Address: 198, Raikes Lane, Bradford, BD4 6RD

Application number: 2026/91516	
What is the application for?:	Removal of car port, relocation and alterations to existing detached garage, ere
Address of the site or building:	200, Raikes Lane, East Bierley, BD4 6RD
Postcode:	BD4 6RD

Title 3D Views

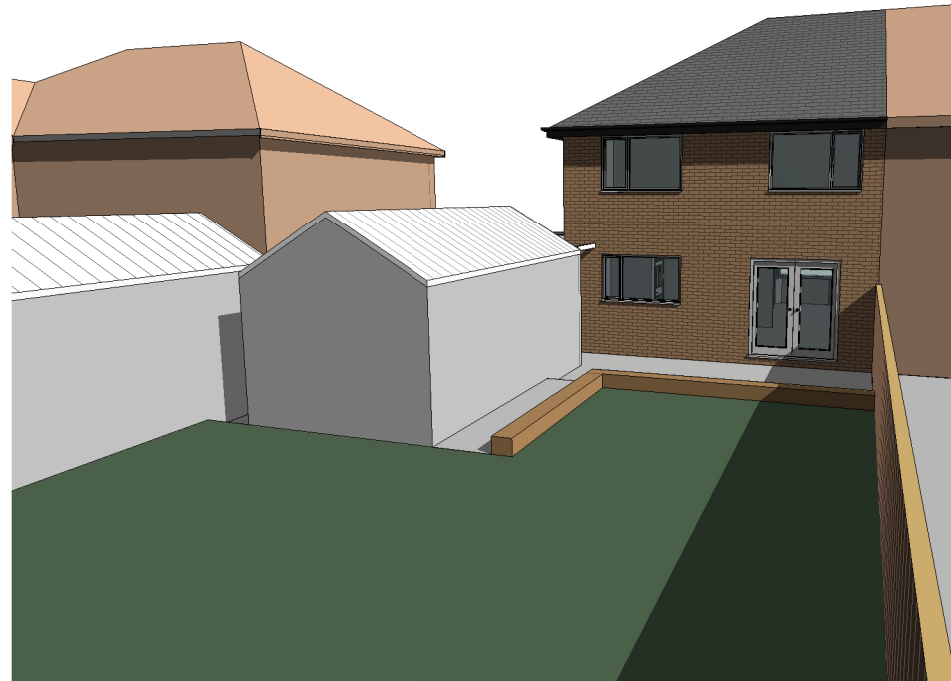
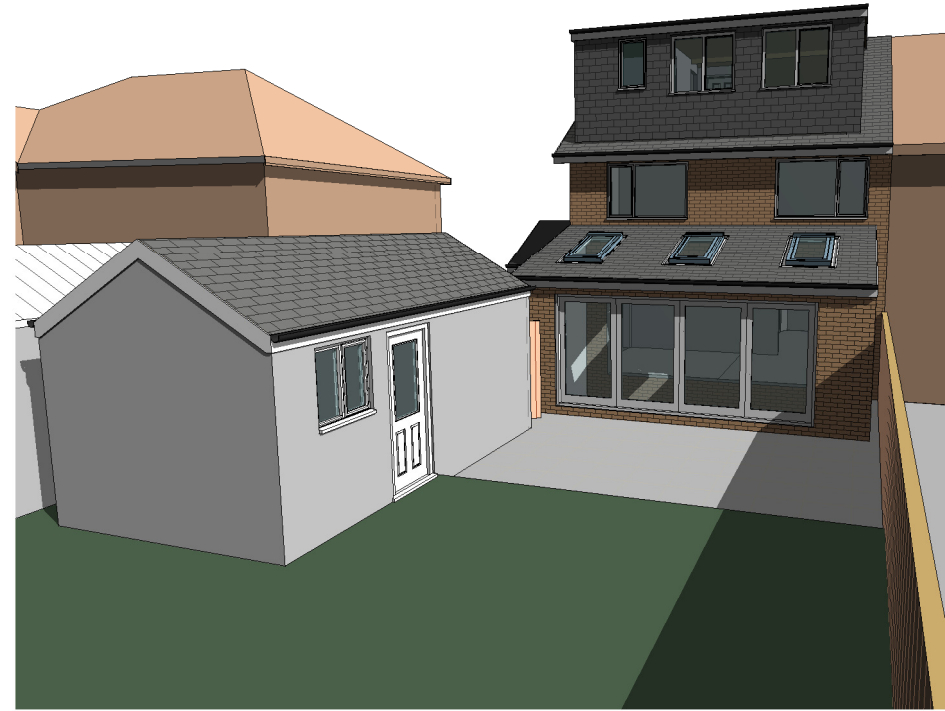
Type of comment: An objection	
Do you wish your comments to be published on the website anonymously?	No
The proposed rear loft conversion/dormer window installation would create an elevation higher than any of the surrounding properties. As our garden runs parallel and behind the property at 200 Raikes Lane, this would result in a significant loss of privacy in many parts of our garden, in particular our patio/family seating area would now be overlooked. We would therefore ask that this part of the proposed development is rejected in its current form.
